**Application** H08-1023-25  
**Location** Risegate House Farm Hedgefield Hurn Gosberton Risegate PE11 4JE  
**Proposal** Residential Development comprising 1 new dwelling and conversion and extension of existing agricultural building, demolition of existing agricultural building and proposed new farm access track

**Name** Ruben Lopez Catalan  
**Address** Lincolnshire County Council, County Offices, Newland, Lincoln LN1 1YL  
LN1 1YL

**Date Submitted** 20-11-25  
**For/Against** Comments

**EXISTING GROUND FLOOR PLAN**  
 1 : 100

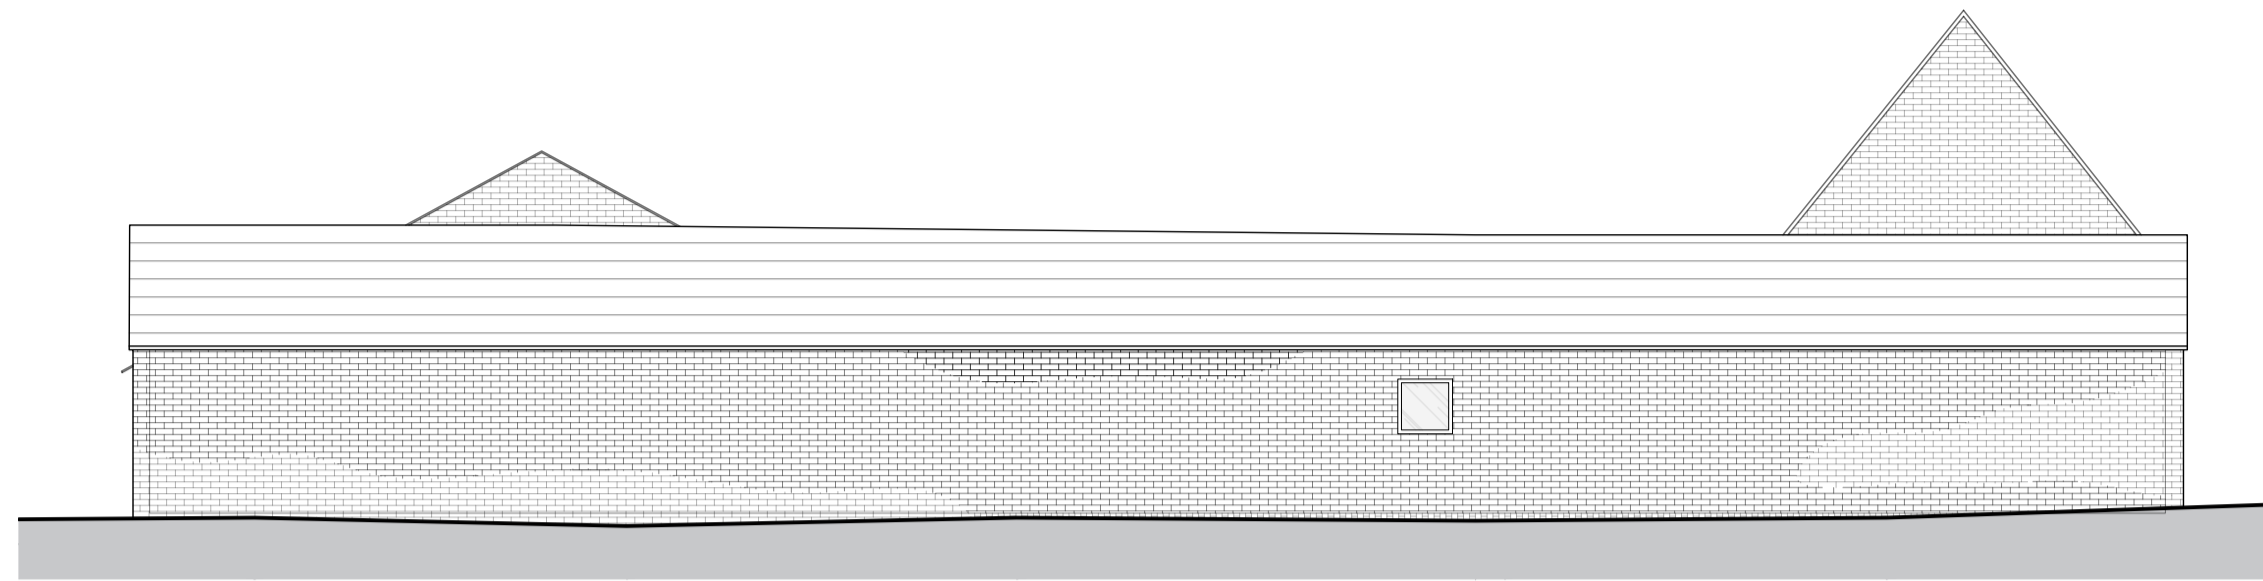
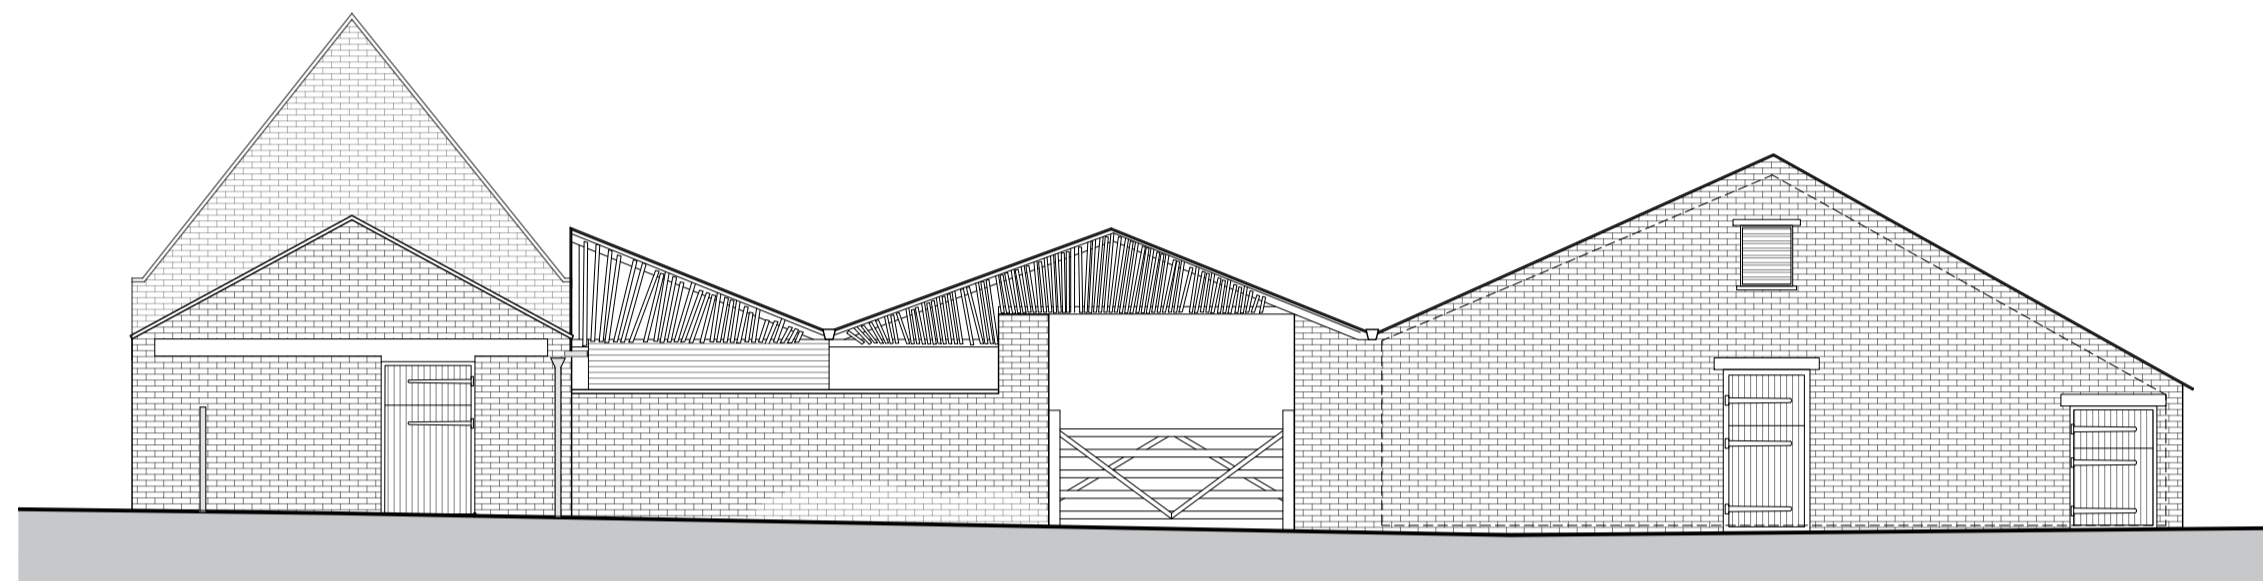
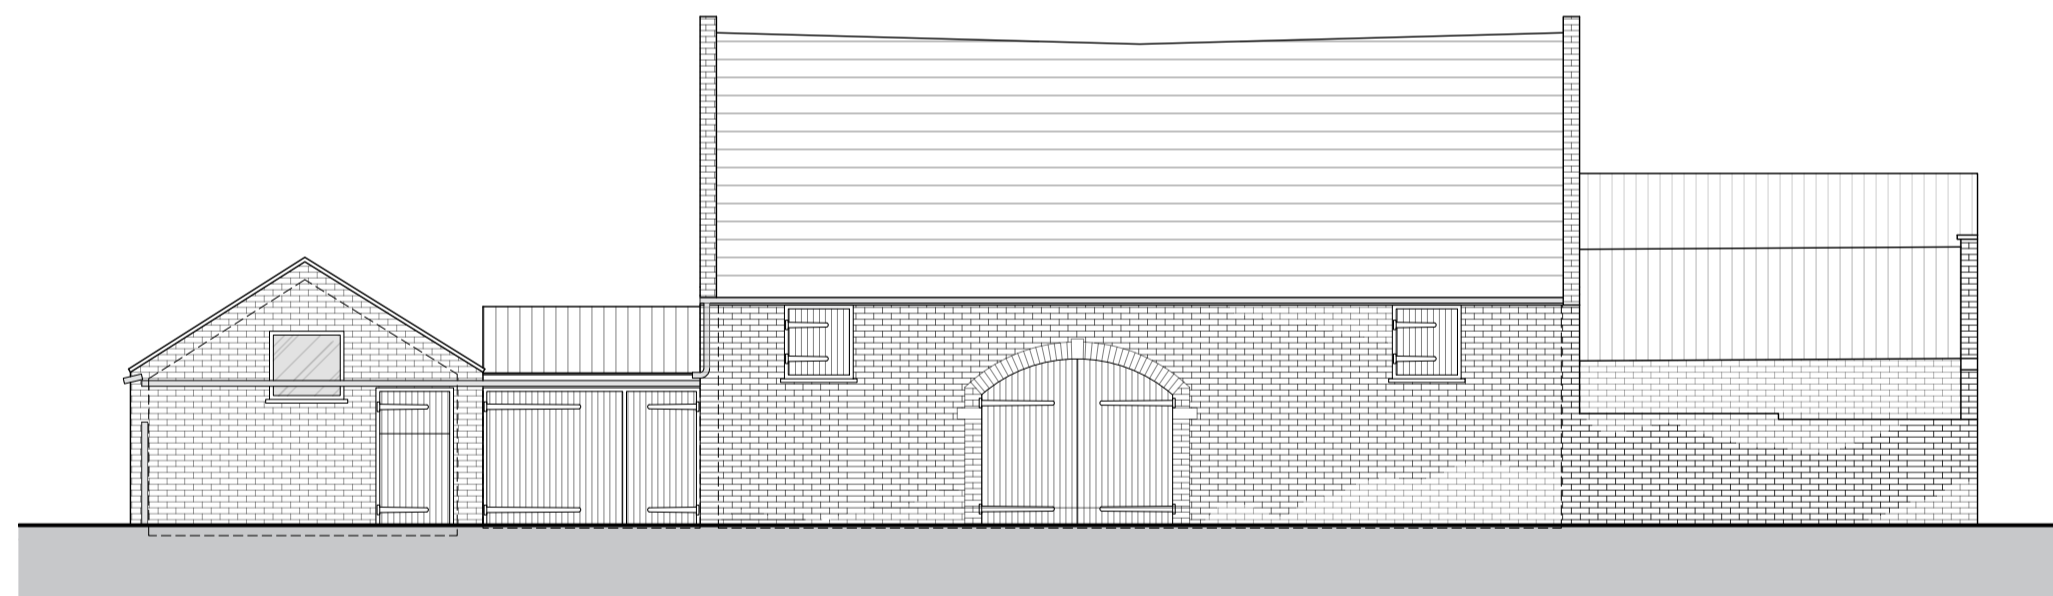
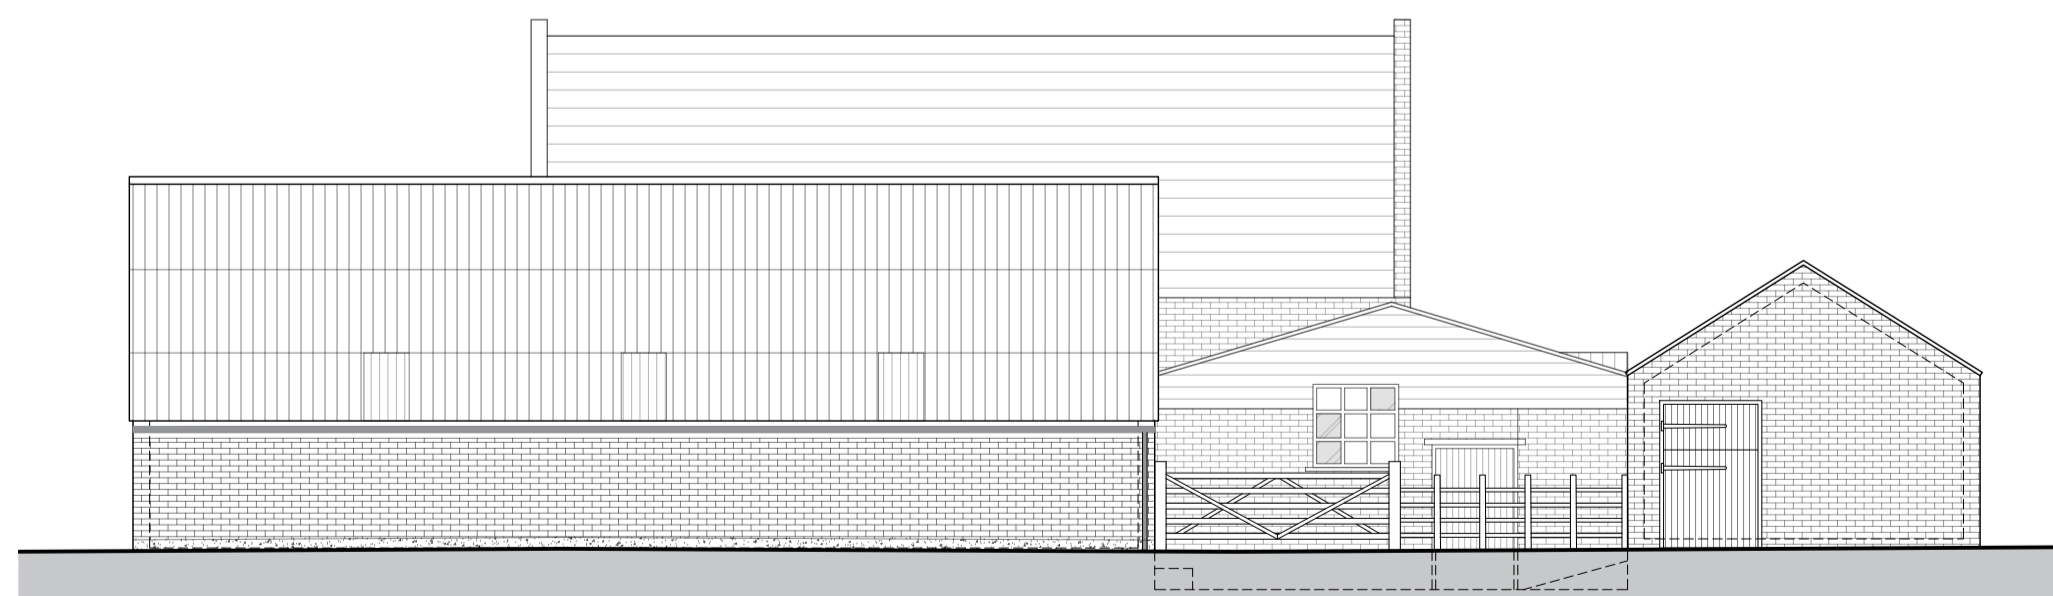
Historic mapping information - OS Map 1892-1914 in the HER (Historic Environment record) confirms that the existing agricultural building to be converted is an extant part of Building record MLI122527 - Risegate House, Gosberton: Partially extant 19th century farmstead.

The existing farmstead building on site are considered a non-designated heritage asset (NDHA) due to their distinctive construction. Documented examples predating the 1880s are rare, and farmsteads dating from 1880-1940 are referenced in Historic England's Agricultural Buildings: Listing Selection Guide (April 2011) and the Greater Lincolnshire Farmsteads Project (Historic England, 2015). These structures display highly distinctive architectural characteristics and possess notable heritage value.

Conversion will have a significant impact on any surviving original fabric of the farmstead building.

I recommend that if permission is granted, there be a condition for a mitigation strategy to effectively deal with this site.

This will comprise a phased programme of mitigation work including, but not limited to, a level 3 historic building recording of the farmstead building, in accordance with Historic England's document 'Understanding Historic Buildings: A Guide to Good Recording Practice. (2016).'

This will enable the farmstead building to be recorded prior to conversion.
